From: [REDACTED]
Sent: 09 May 2022 09:56
To: Planning
Subject: Amended planning application no 3/2022/0421

Regarding amended planning. Concerns as follows :-

PROPOSED NORTH EAST ELEVATION (FRONT). SCALE 1:100

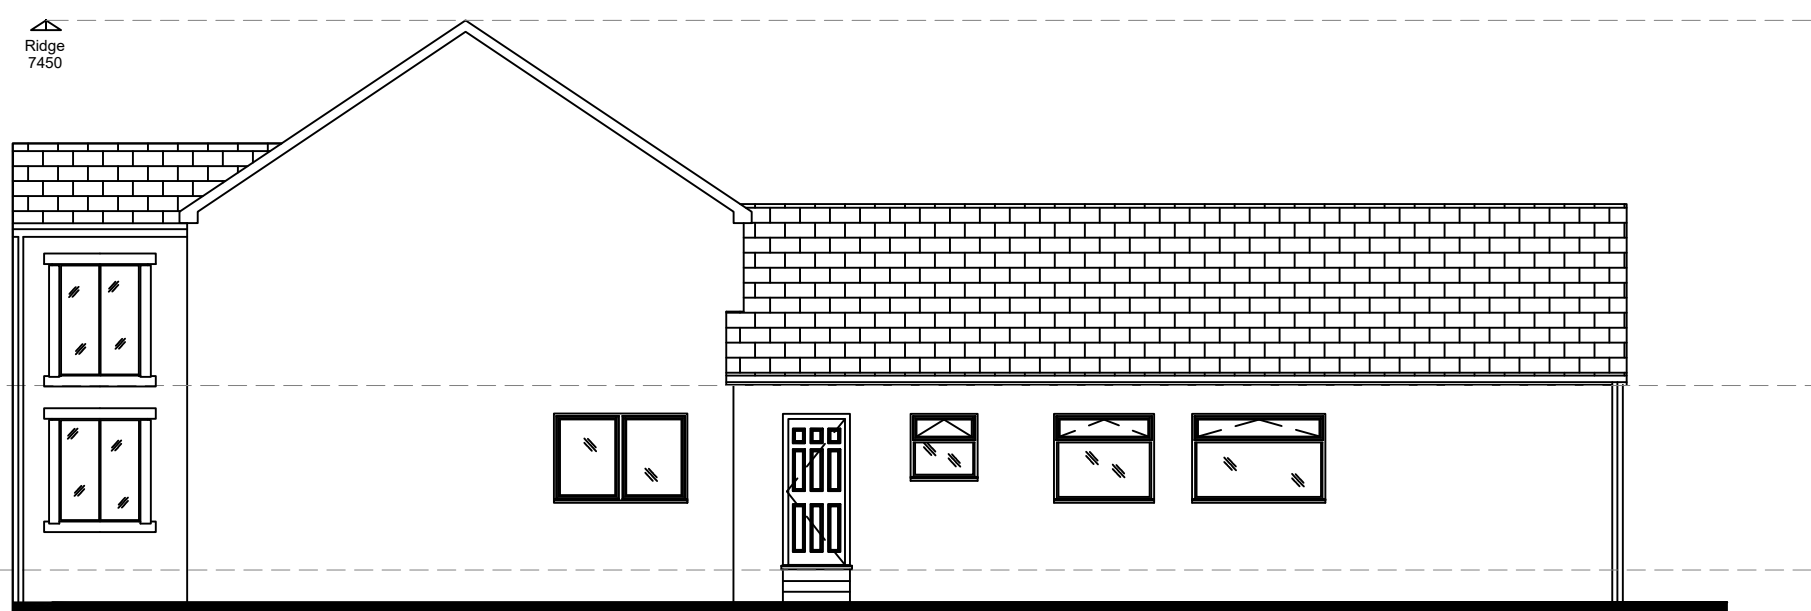
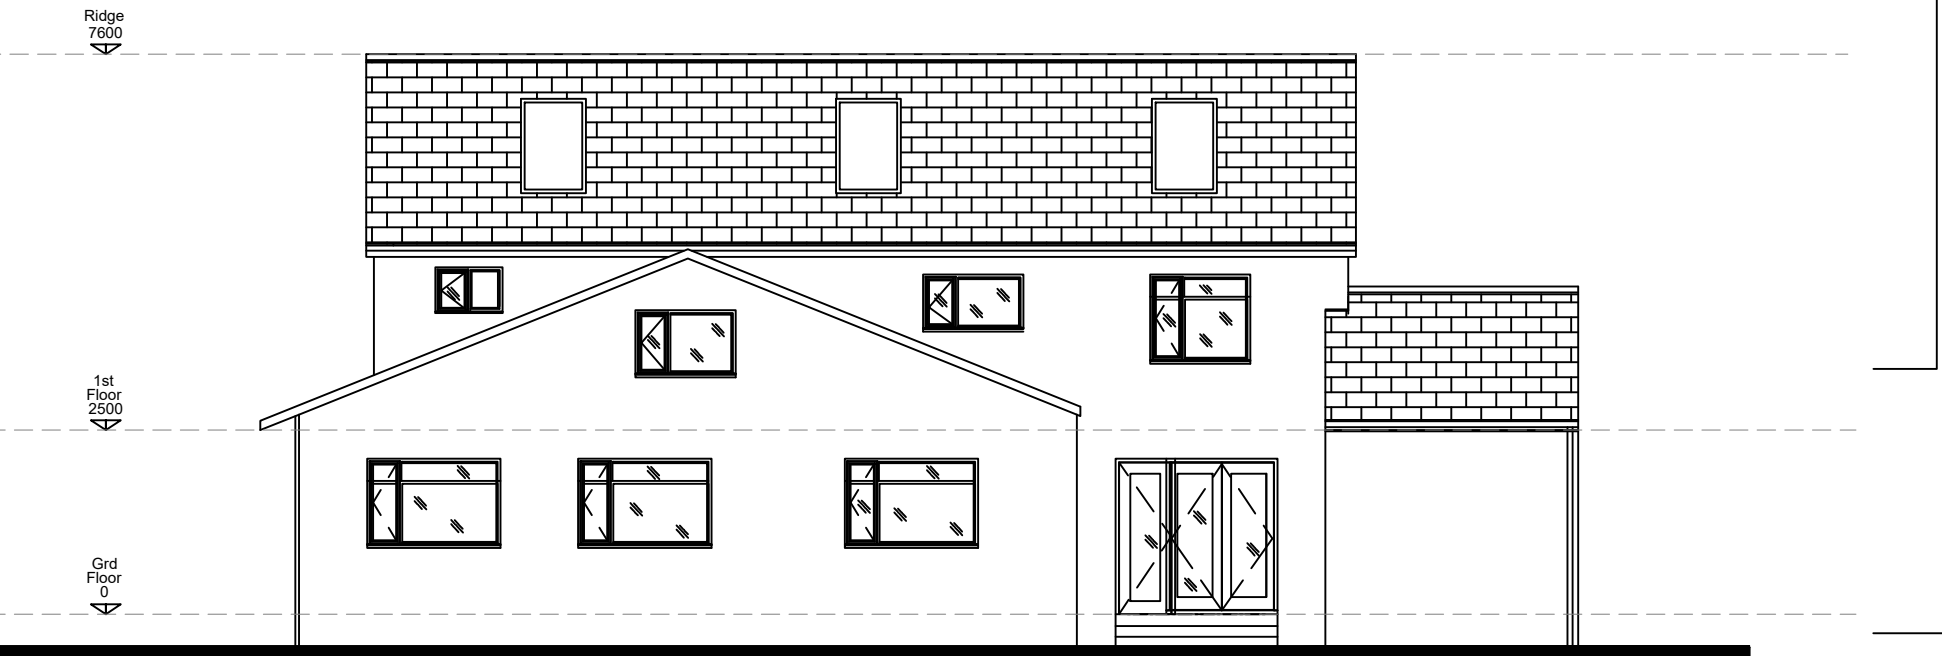
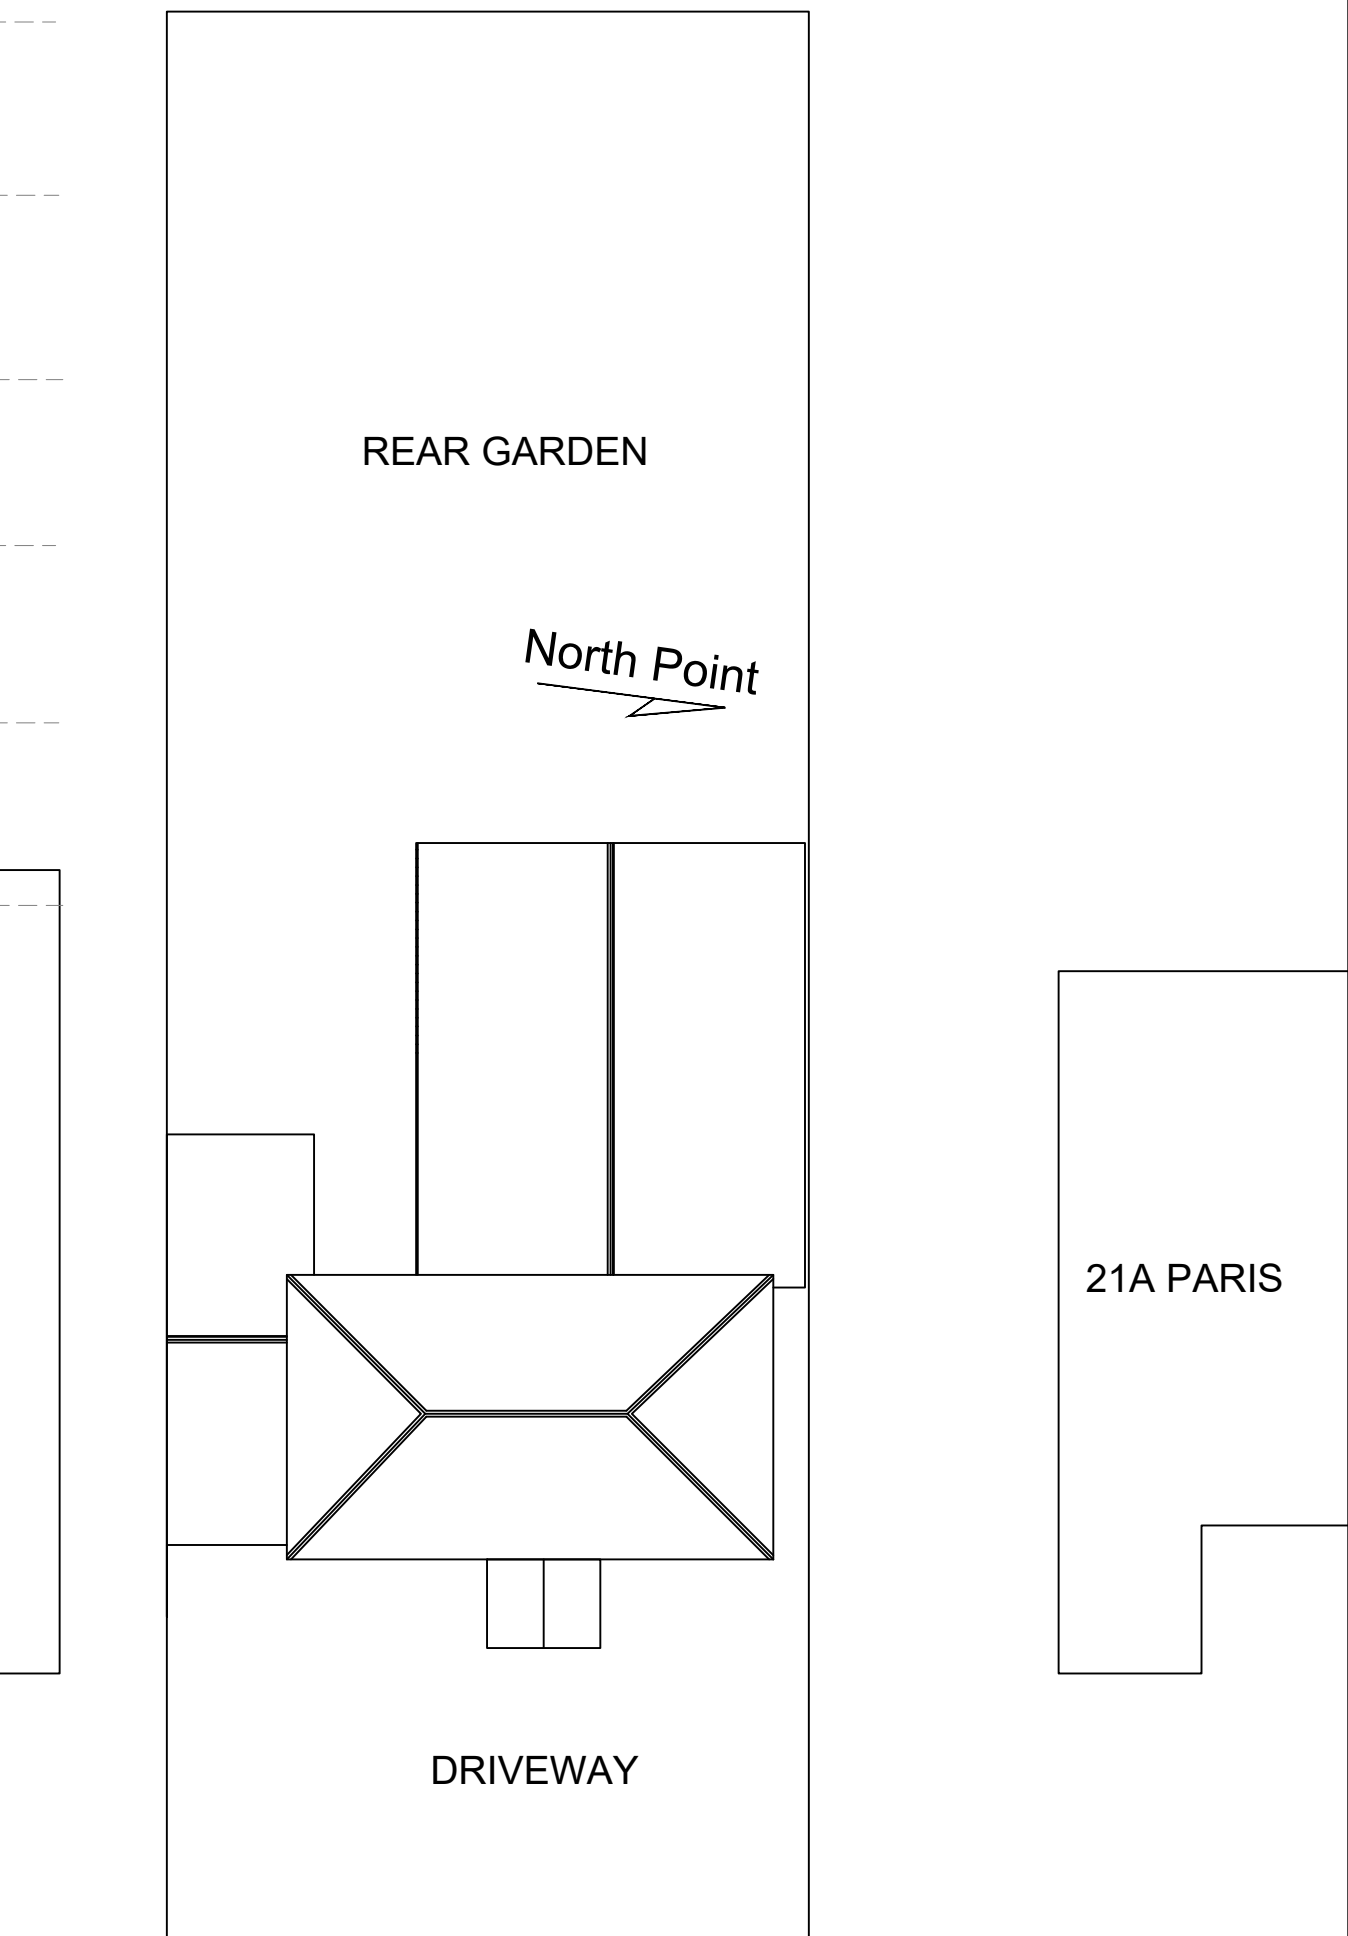
1. Loss of privacy due to new added large balconies and large window lights on the 3rd floor [REDACTED]
- [REDACTED]
